F2006/00713 (D02426036)

Section 75W Modification of MP 05_0120 - Orora (formerly Amcor) Paper Mill Project

Thank you for inviting Council to provide comments on the submission report prepared by Jacobs and dated 29 May 2015. The Jacobs' submission report considers Council's previous submission to the Department of Planning & Environment (DoPE) on the Section 75W Modification dated 13 April 2015.

Figure 7: Proposed relocation of existing driveway

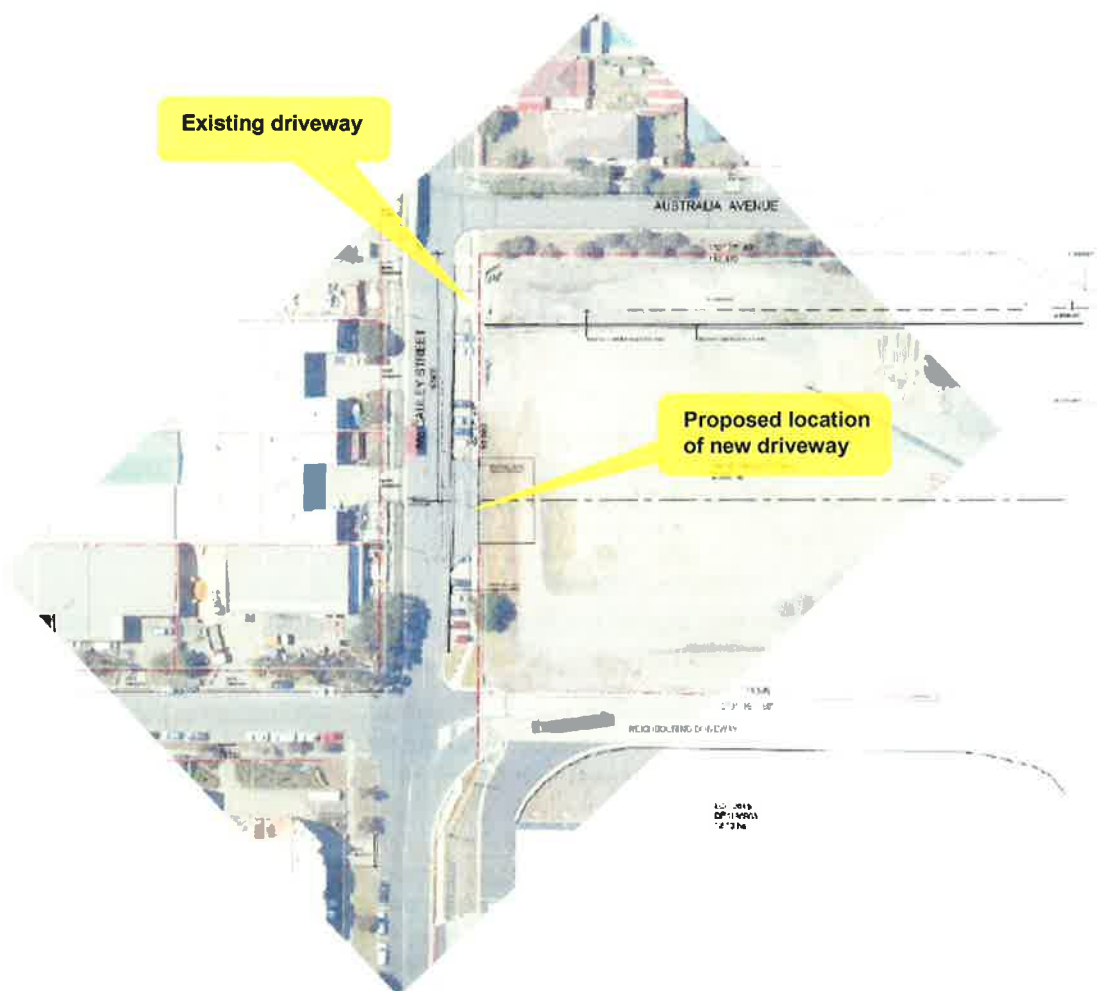
The subdivision to create Lot 2014 DP 1195903 should have been referred to Council for comment prior to being endorsed by the DoPE and the CDC for the development of Lot 2014 DP 1195903 should not have been issued without a formal referral by the Certifier to Council for comment and approval of works within the McCauley Street road reserve.

Following on from the registration of a plan of subdivision in October 2014 a Complying Development Certificate (CDC) was issued 3 February 2015 for development on Lot 2014 DP 1195903 (Lot 2014). The CDC was issued by Blackett Maguire Goldsmith Pty Ltd without the required written consent of Council as the relevant Roads Authority under Section 138 of the Roads Act 1993. The CDC documentation contains a checklist which states that no referral to Council was required however Council contests this omission and believes that referral was a prerequisite to the issuing of a CDC. The proposed modification to the site access directly relates to the subject CDC and, in effect, is seeking to remedy a potentially invalid consent. The design of the vehicular access and the entire traffic report submitted with the modification relates to the development approved under the CDC. Council's preference is for vehicular access for Lot 2014 DP1195903 to be provided via the internal road network within Lot 2015 DP1195903 with the creation of appropriate rights of carriageway.

The CDC was approved with no formal referral to Council by the Certifier (Blackett Maguire Goldsmith). Council has consistently maintained that the stormwater overland flow management issue must be resolved prior to any further development of the Orora site (including Lot 2014 DP 1195903). Council has also consistently maintained that Orora's main McCauley Street access should be used to access Lot 2014 DP 1195903.

Jacobs states that Council has not specified which section of the road is to be upgraded. Council's recommended condition of consent specifically says *"Prior to the commencement of any construction works within Lot 2014 DP 1195903 (Lot 2014) the applicant must submit to Council for approval, and have approved, detailed design plans for the reconstruction of McCauley Street along the full site frontage of Lot 2014 DP 1195903"*. The works are required in McCauley Street along the full site frontage of Lot 2014 DP 1195903.

Apart from construction of a new concrete footpath no civil works have been carried out in front of Lot 2014 DP 1195903. Council, in its submission of April 2015, conditioned significant civil works in McCauley Street. Jacobs has stated that Orora won't do these works and provided a number of reasons. The submission report then goes on to say that some of the civil works conditioned by Council will be paid for by the developer of Lot 2014 DP 1195903. Council believes that the scope of works for civil works previously conditioned is appropriate. Council does not have an issue if the works are paid for by the developer of Lot 2014 DP 1195903 or Orora.

Council's previous submission to the DoPE on the Section 75W Modification dated 13 April 2015 is relevant with respect to the potential loss of on-street parking associated with the Section 75 W Modification. Vehicular access via the internal road network within Lot 2015 DP1195903 would minimize the loss of on-street parking.

Figure 8: Proposed amendment to the subdivision layout

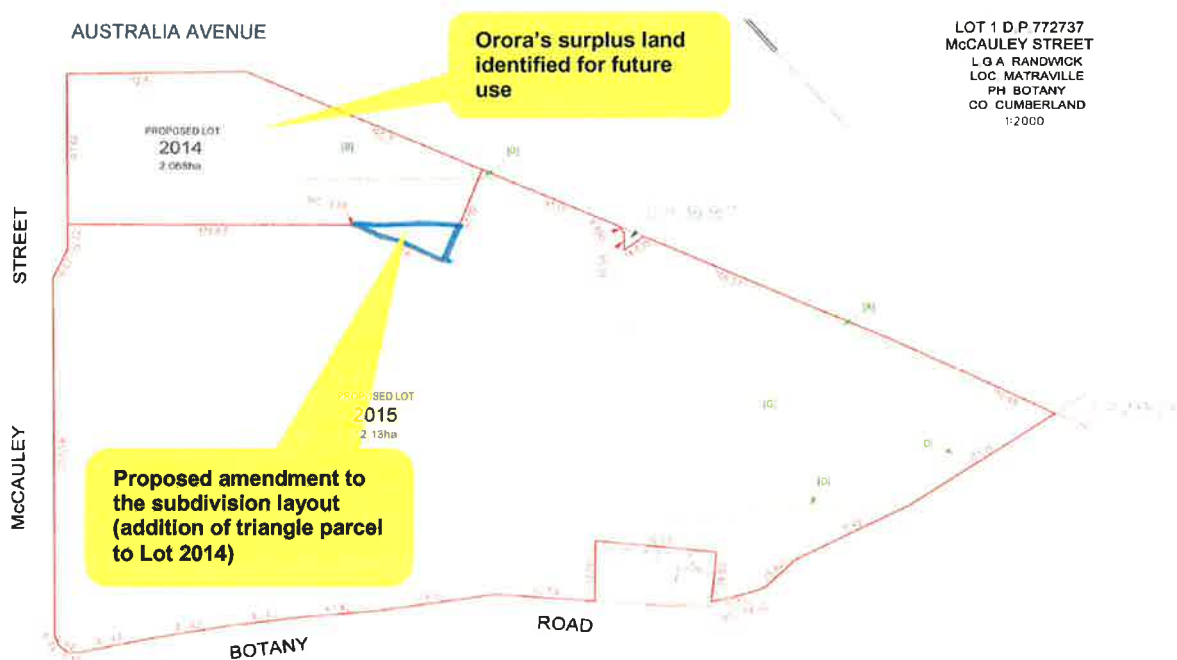
As noted in Council's original submission on this Section 75W Modification, part of the modification application is for a minor alteration to the subdivision plan that applies to Lot 2014 DP 1195903. The alteration is to a plan of subdivision that has been endorsed by the Department of Planning and Environment and contains a number of easements, (in particular reference is made to easements for overland flow). The type of easements and the implications of the easements are such that the proposed plan of subdivision should have been referred to Council for comment prior to its registration. This application is therefore seeking a minor modification to a plan of subdivision that in Council's opinion has easements/terms of easements that are unsatisfactory.

Lot 2014 DP 1195903 contains easements for overland flow. Whilst these easements do not take stormwater directly from the development the subject of the CDC, they do form part of the site's stormwater system. If they were not there the approved development would suffer stormwater inundation during major storm events. Note: the final approved stormwater drainage plans for the development on Lot 2014 DP 1195903 do not appear to have been submitted to Council with the CDC.

**Figure 10:** Predicted night-time noise levels from operation noise with interim noise mitigation works

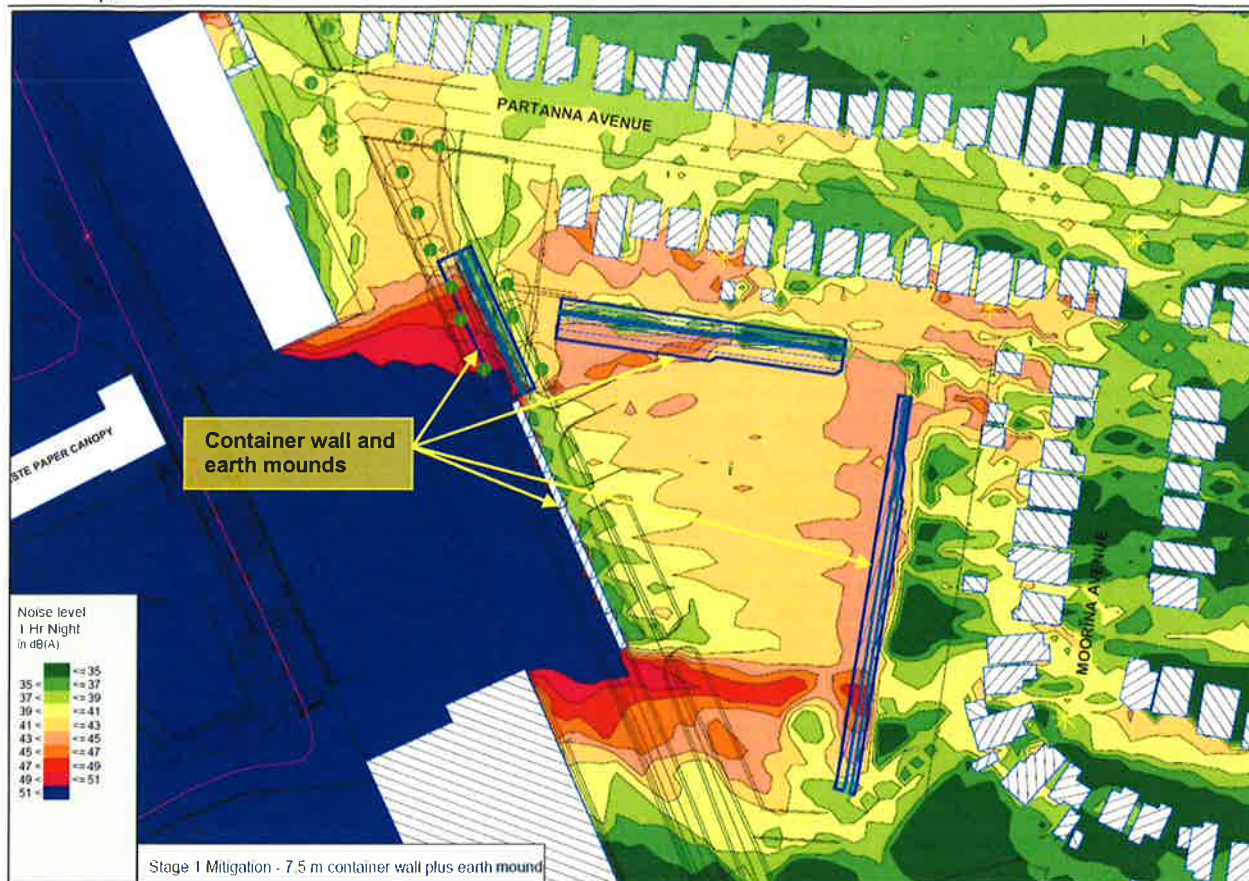
The removal of the building will increase noise emanating from the Port and Orora activities. As such noise walls both interim and permanent are proposed. It is understood and generally accepted that building/demolition will cause some degree of high intensity noise, however given there is a finite end point to this the majority of sensitive receivers are able to accept the noise generated provided communication and availability to reschedule activities with respite can minimise any potential concerns that may be raised. So the exceedences detailed to occur during demolition/construction whilst unfortunate will not result in ongoing noise impacts to the residential receivers. Therefore the interim measures proposed supplemented with a requirement for a demolition management plan addressing amenity is recommended.

In relation to the proposed noise walls in principle these attenuation measures are maximised when they are situated close to the source of the noise or close to the receiver locations this should be factored into the decision making process of the location of the wall to maximise effectiveness. Given the circumstances of the area and the impact of Port Noise, situating the wall as close to residential receivers maybe the preferred option.
